Our Ref: A/124/26/NMA

**Section 96A of the Town & Country Planning Act 1990 (as amended)
Town and Country Planning (Development Management Procedure) (England) Order 2015
(as amended) - Article 10**

Non material amendment following the grant of A/33/26/HH to change tile-clad dormers to timber-clad dormers.

29 Mill Road Avenue Angmering BN16 4HR

Proposed Elevations

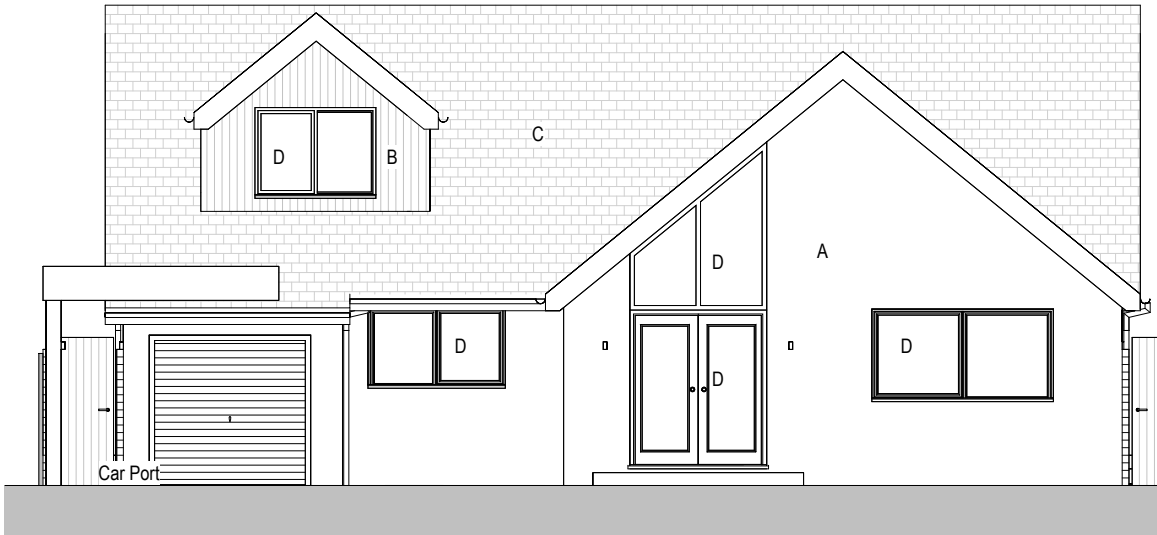
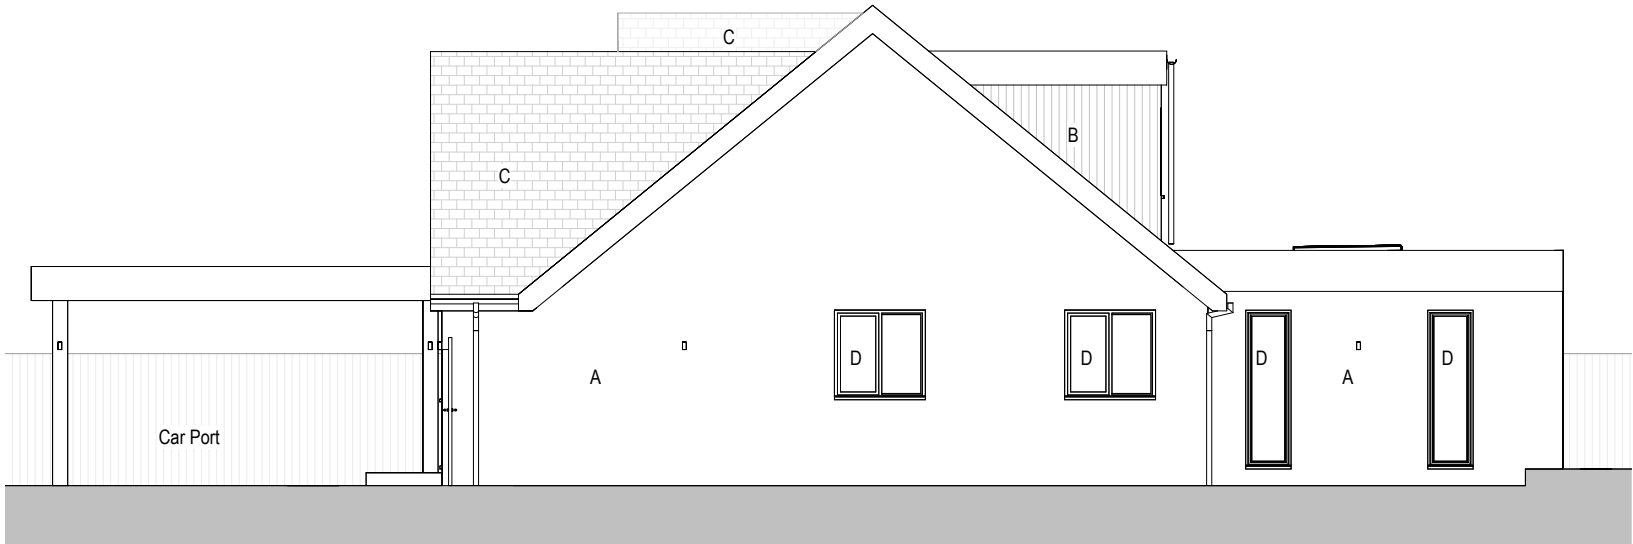
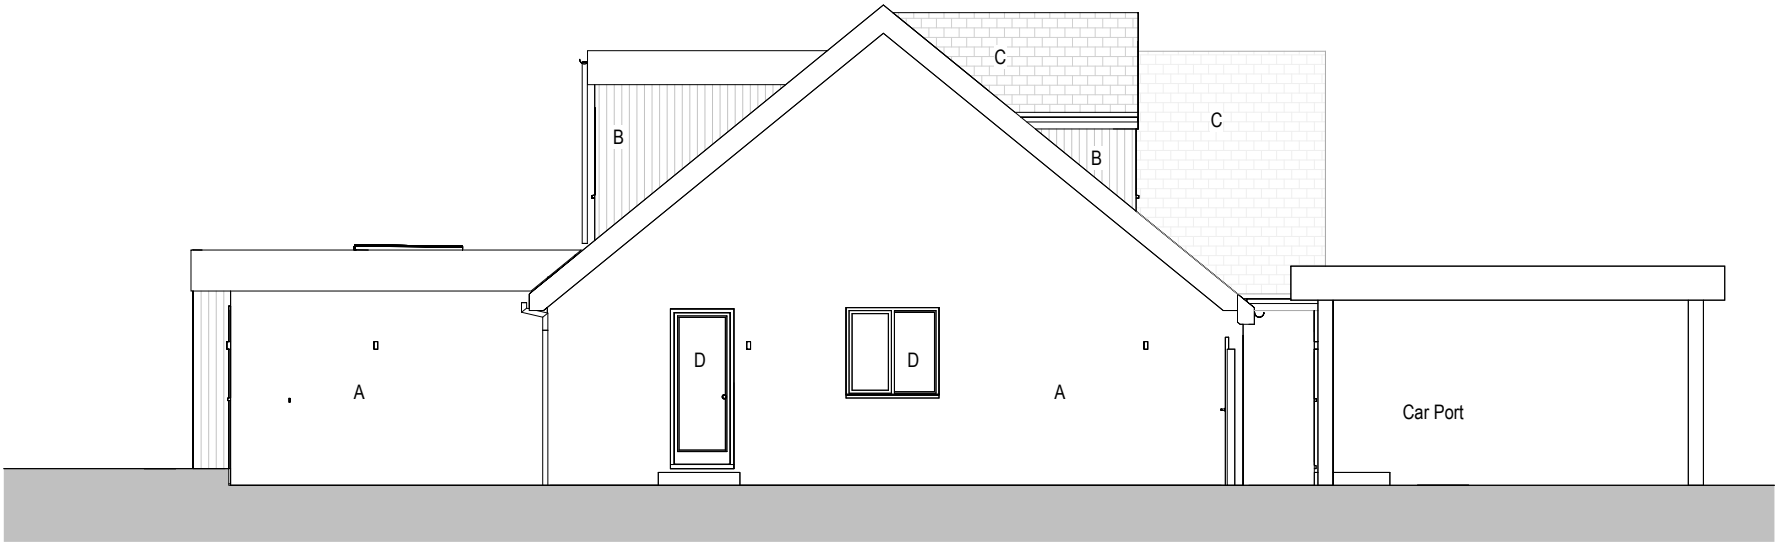
The reason that the proposal has been accepted as a Non-Material Amendment because it would not materially affect the appearance of the building and would not impact neighbouring occupiers. The changes would substitute tile-clad dormers to composite-clad dormers. The use of cladding would continue to reflect the original design approach for the development and would not alter the prevailing character of the host dwelling. The cladding would be isolated to the dormers only. The amendment is therefore considered to be minor in nature and can be determined as a Non-Material Amendment under section 96A of the Town and Country Planning Act 1990.

- Proposed Elevations P009 Rev P1.
